Shivesh Singh - Development of Scottish Hospital, Paddington

From: "Annette Smith" <Annette.Smith@dibbsbarker.com>
To: <plan_comment@planning.nsw.gov.au>
Date: 16/12/2010 4:46 PM
Subject: Development of Scottish Hospital, Paddington

Proposed Shadows - 21st June 2pm

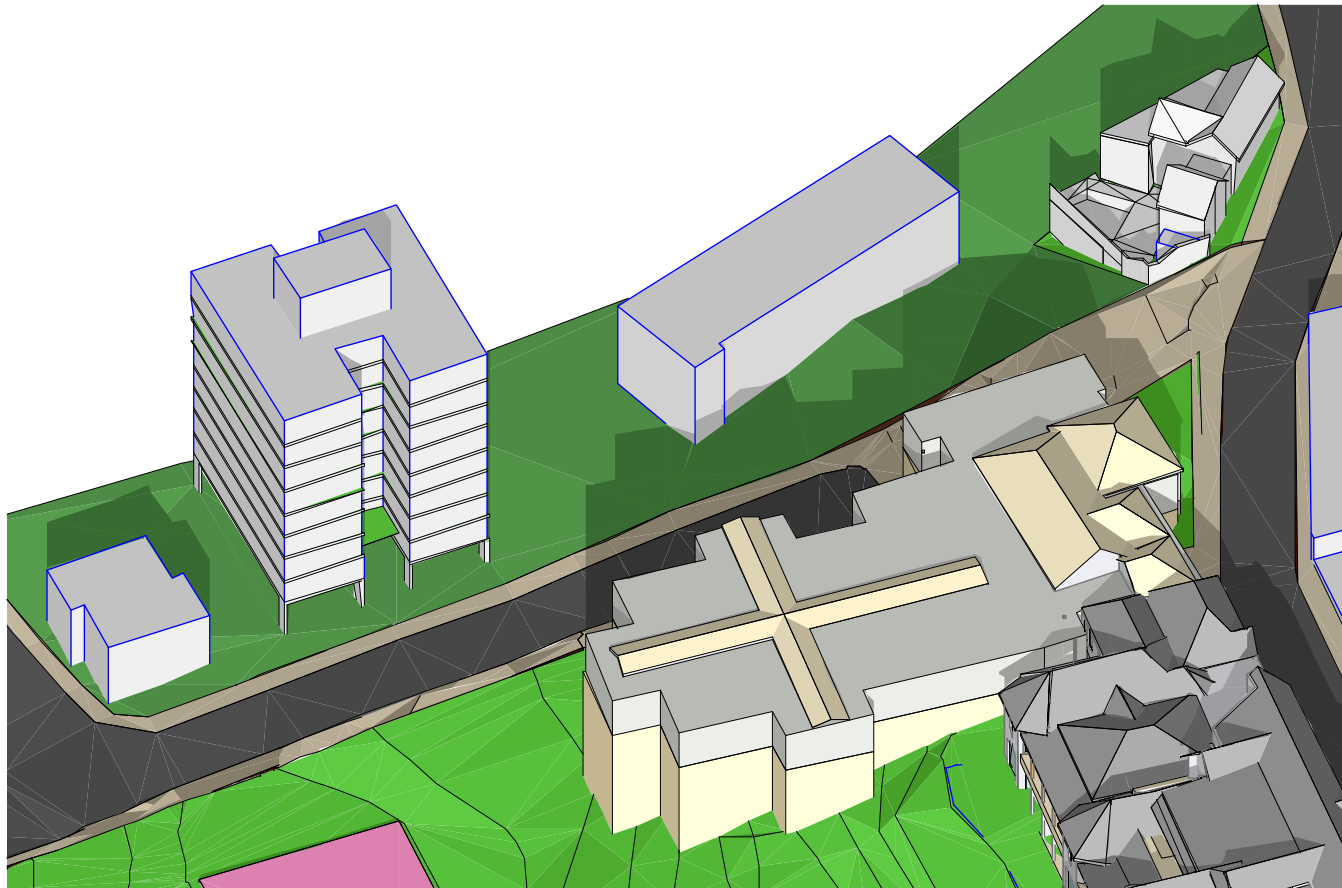
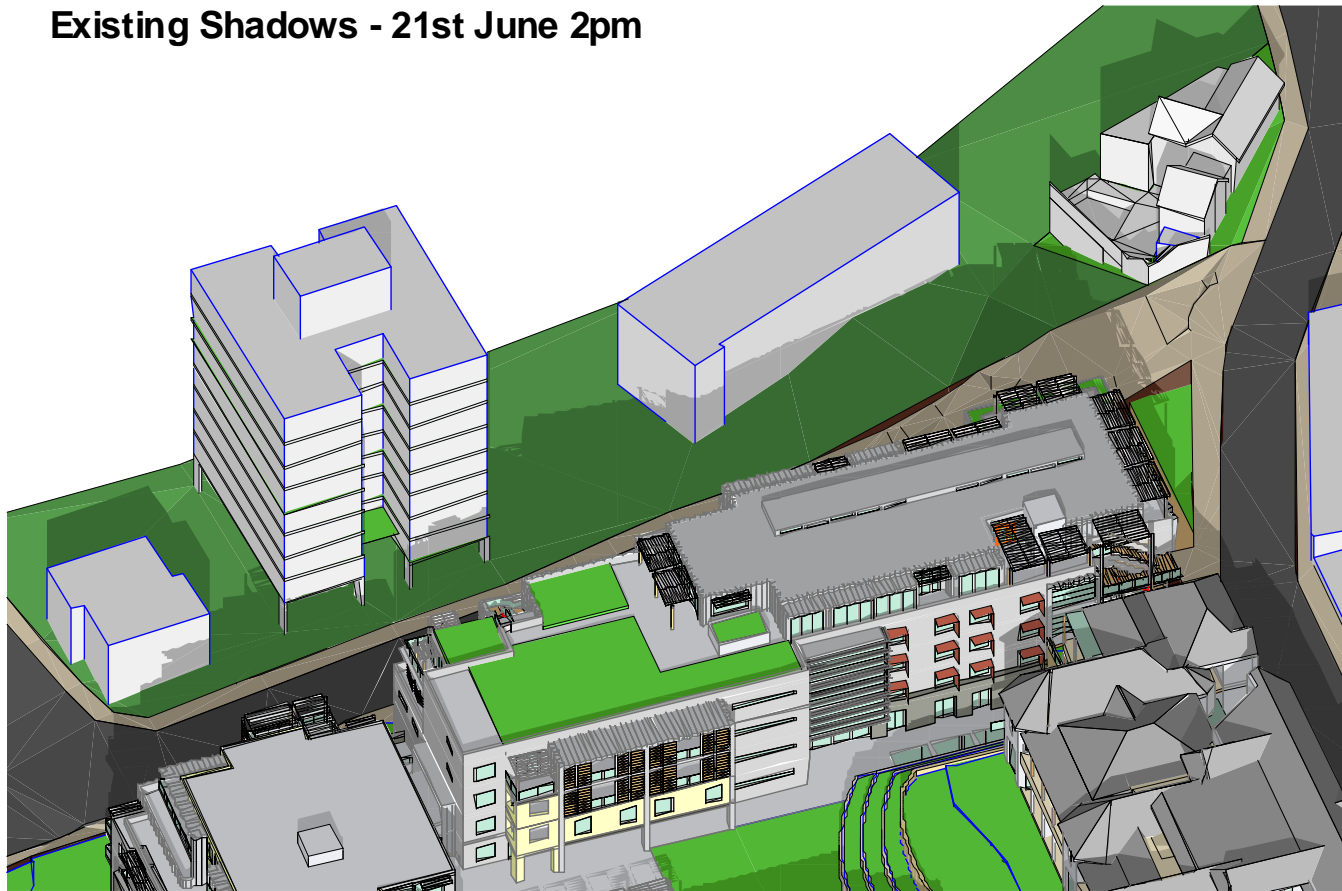
I live at 6/38 Stephen St, Paddington and currently, in winter we lose the sun at 2:00pm-ish and we do not get much afternoon light. The proposed new buildings would make this situation worse.
